REQUEST

Approximately 10.26 acres located on Shopton Road between Steve Chapman Drive and Pinecrest Drive.

The petition proposes to amend a previously approved plan to add a parcel, list additional prohibited uses, and expand to 120,000 square feet of office, warehouse, and distribution uses and outside storage.

Plotted By: Watts, Austin Sheet: Set Shopton Rezoning - Layout-RZ-1 TECHNICAL DATA SHEET March 20, 2023 06:28:13pm K:\CHL\PRJ\015272_AAC\048 Shopton Road Industrial\02 - DWG\PlanSheets\Rezoning\RZ-1 TECHNICAL DATA SHEET.dwg

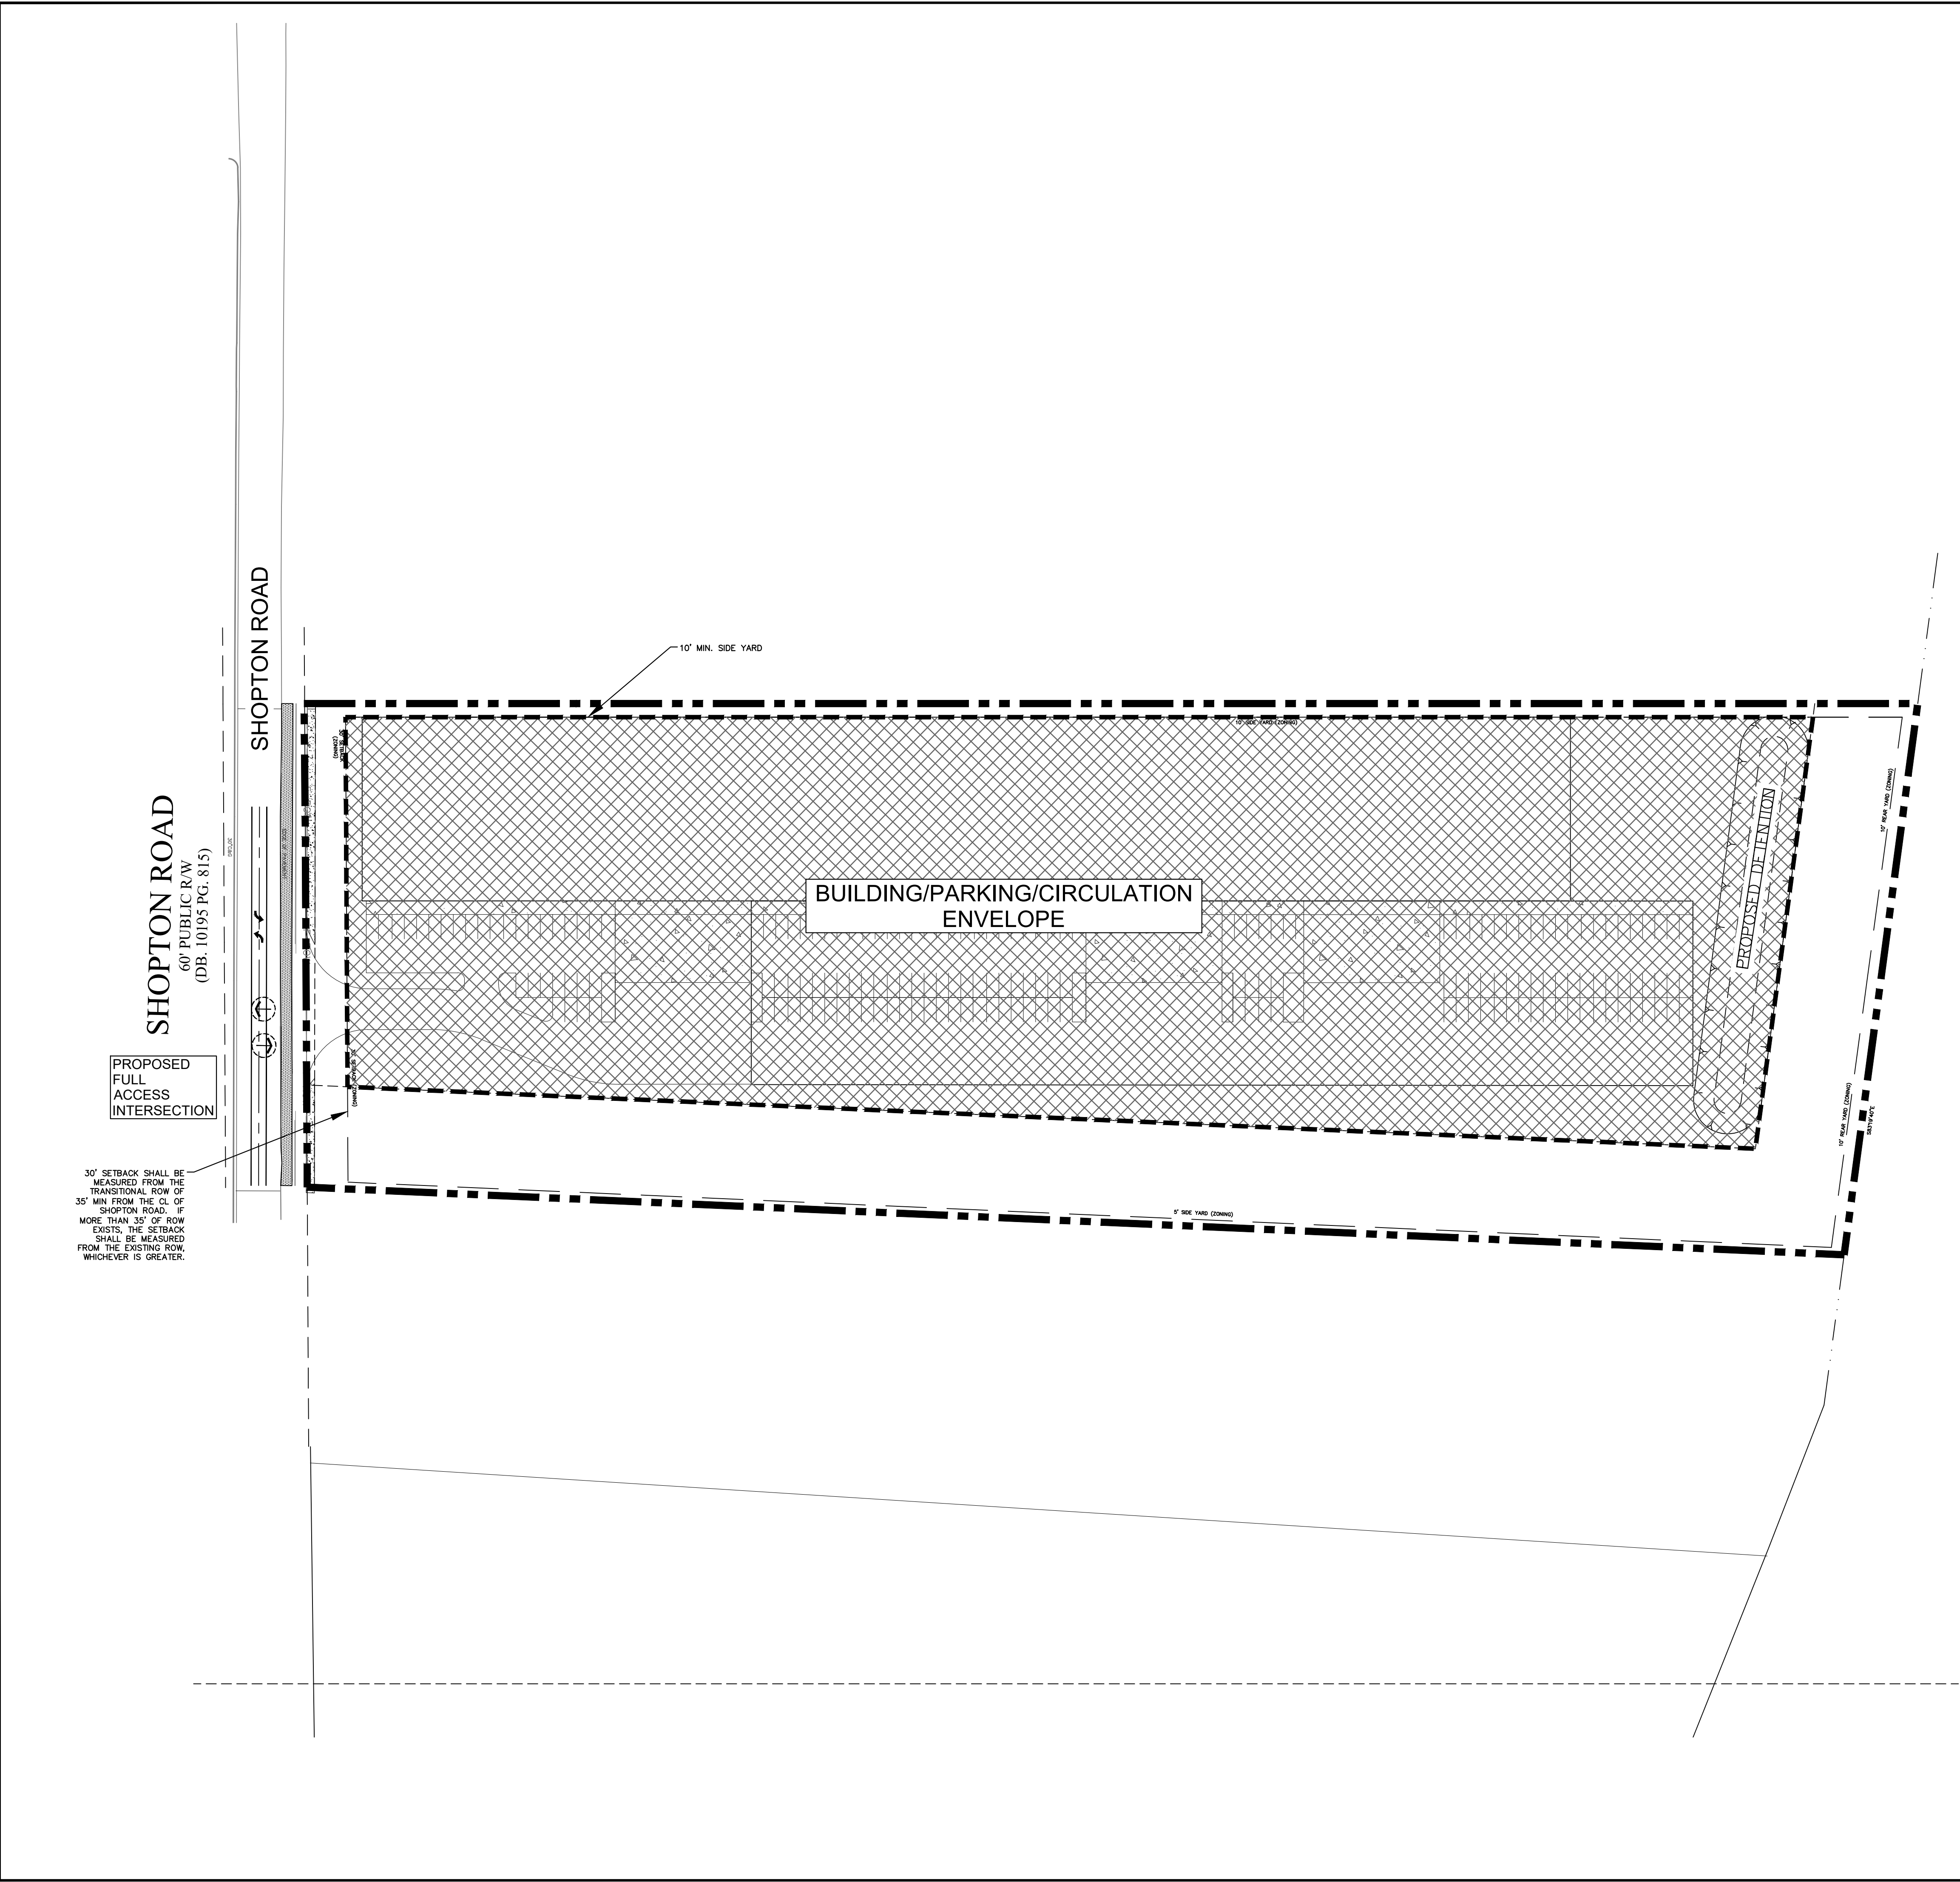
- ~~1. Label and dimension the curb and gutter at 27' from the centerline of Shopton Road on the site plan.~~
ADDRESSED
- ~~2. Revise site and plan and conditional notes to commit to constructing an 8' planting strip and 8' sidewalk as specified in the Charlotte Walks policy.~~ ADDRESSED
- ~~3. Add a conditional note that the entire sidewalk must be outside of the right of way and within a public access easement. Add a conditional note committing to construction and maintenance of the 8' sidewalk on Shopton Road.~~ ADDRESSED

- ~~4. Delete all items that were applicable to the previous petition but not to the current petition.~~
ADDRESSED
- ~~5. Illustrate on the site plan right of way at 35' from centerline and 20' setback. Remove hatching from area within the setback. No use or parking and maneuvering are permitted within the setback.~~
ADDRESSED
